**KIRKLEES METROPOLITAN COUNCIL  
INVESTMENT & REGENERATION SERVICE**

**DELEGATED DECISION TO DETERMINE PLANNING APPLICATIONS**

**Reference No:** 2021/62/90128/W

**Site Address:** 41, Meadow Lane, Slaithwaite, Huddersfield, HD7 5EX

East Elevation

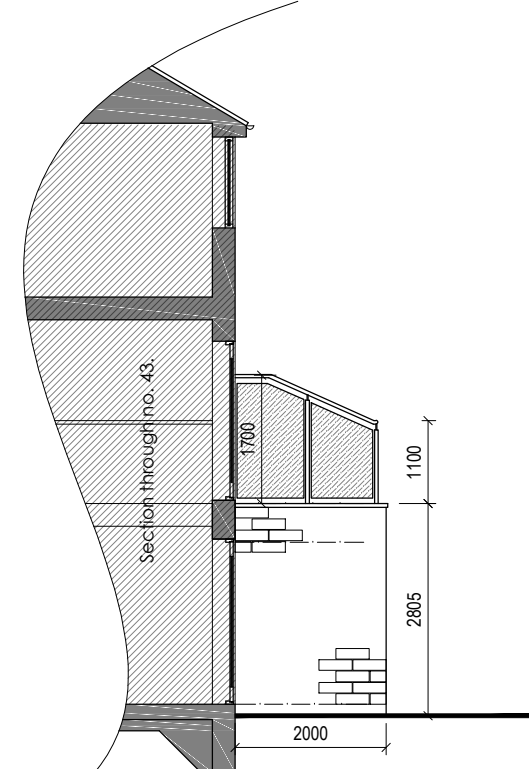
The case officer considered the application on review and received amended plans taking into account representations to change the balustrading to obscured glass at the sides.

- Overshadowing with a 4m high brick wall, would be better with glazed balustrade.

With regard to no. 43, the limited 2m extension is located to the east of the property. The extension is set off the joint boundary and now includes lightweight opaque glazing for screening to the roof terrace. This would prevent undue overlooking from the balcony area whilst reducing the mass of the scheme when viewed from this property. The patio doors and patio area would still receive direct sunlight and enjoy an open aspect to the south and would not suffer undue overshadowing or overbearing impact.

4. The hereby approved roof terrace shall not be brought into use until the glass balustrades measuring 4505mm to taper to 3905mm in height from the floor level of the roof terrace on both the west and east sides of the roof terrace have been erected in full accordance with approved plan ref: 'Dwg ref: 41ML/P02-Rev A'. The west and east balustrades shall be constructed from obscure glazing which shall be equivalent to or more obscure than Pilkingtons Glass grade 4 privacy level. Notwithstanding the provisions of the Town and Country Planning (General Permitted Development) (England) Order 2015 as amended (or any Order revoking or re-enacting that Order) the balustrades shall be thereafter retained with the same obscure glazing privacy level.
